Our reference: P-675541-Y8Z7  
Contact: Sandra Fagan  
Telephone: (02) 4732 7992

**Council Response to Modification Report for SSD-9522-Mod-6, Kemps Creek Estate Warehouse, Logistics and Industrial Facilities Hub (The Yards/Altis/Frasers) at 657 - 769 Mamre Road, Kemps Creek, NSW, 2178.**

Figure 3A: Subdivision Plan – Stage 2 (Lots 1, 2, 3, 4 & 19)

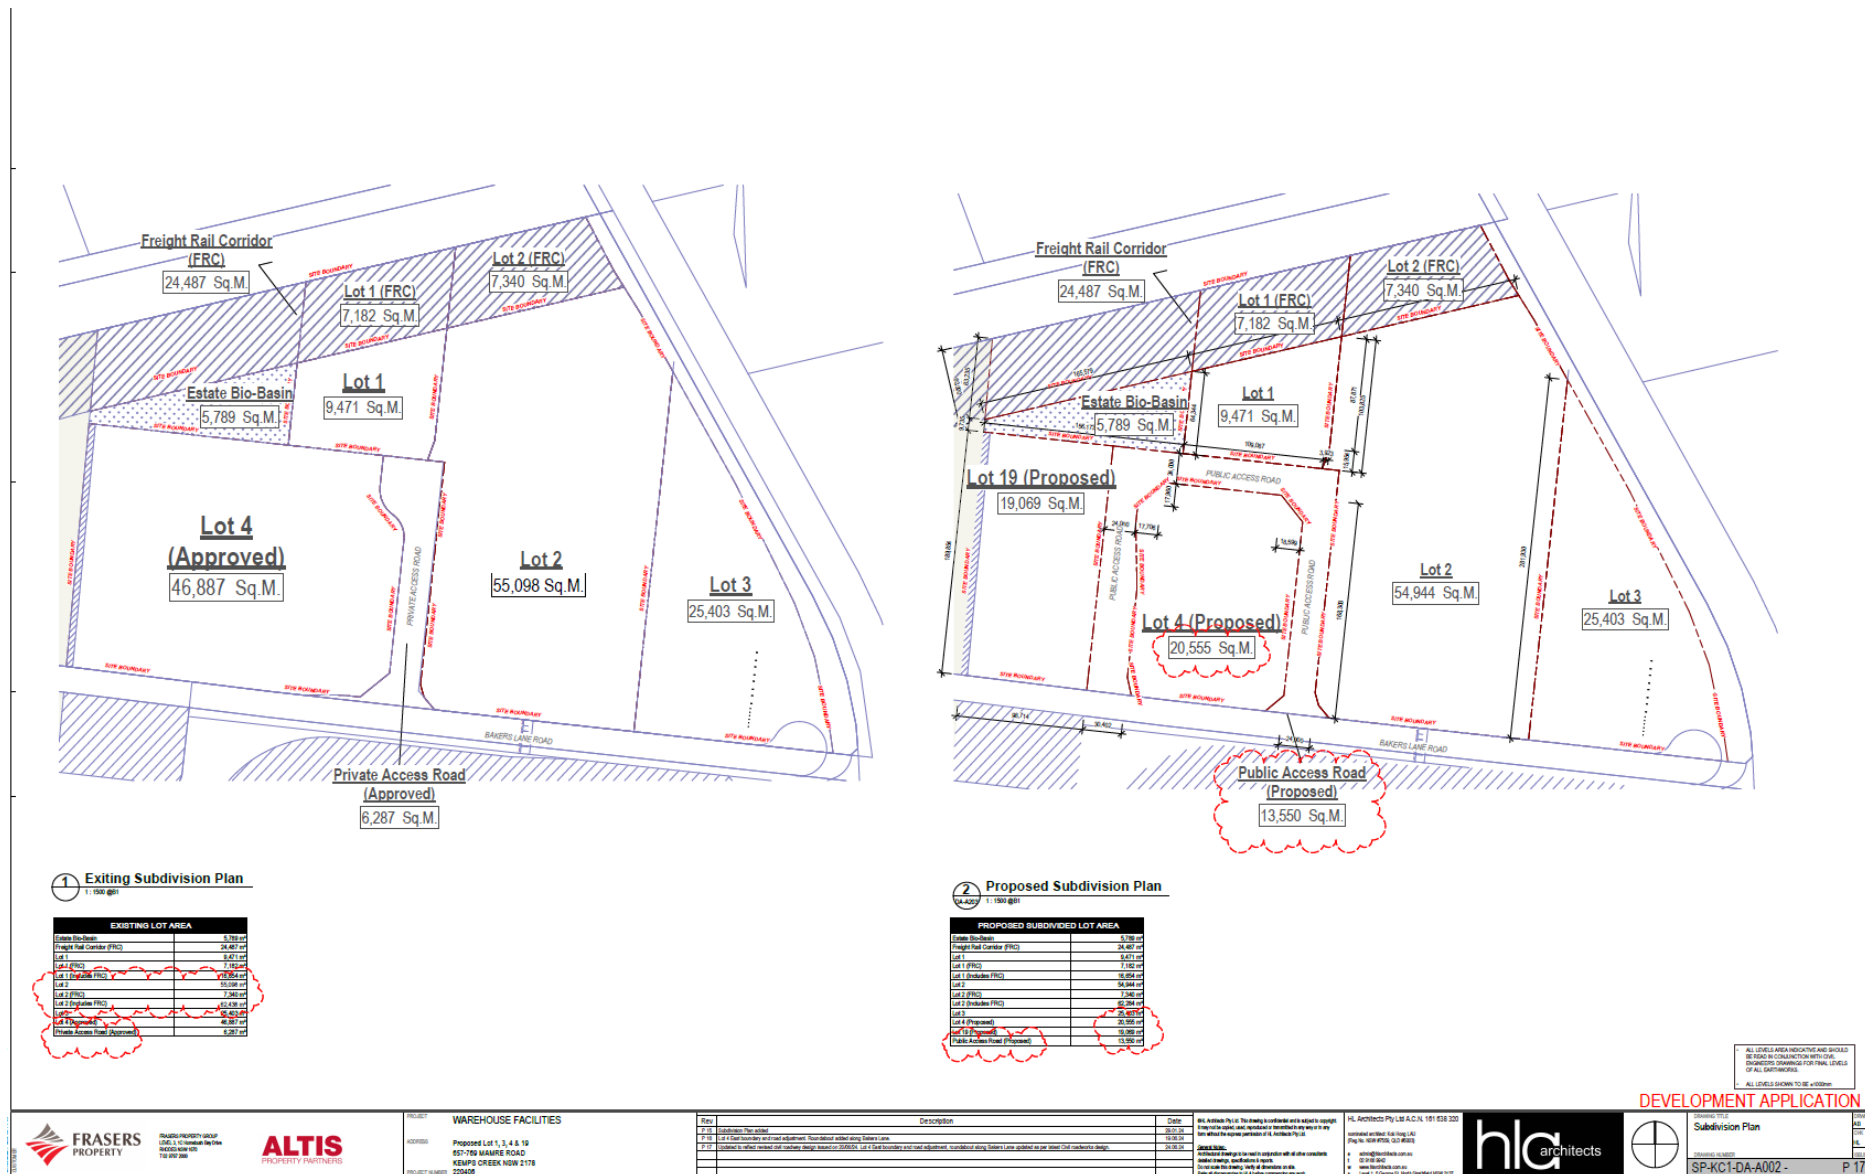
- b) The proponent should demonstrate why the internal master planning for lot 4 does not include an extension of the internal private access road, to provide the required access and manoeuvring space onsite, with entry and exit from the existing approved driveway off Bakers Lane.

- d) Given that Lot 4 appears to result in an intensification of use by proposing to be subdivided into four lots/warehouse uses (Lots 4, 19A, 19B, and 19C), it would be prudent to require those new lots to be fully accessible and serviced by new internal roads.
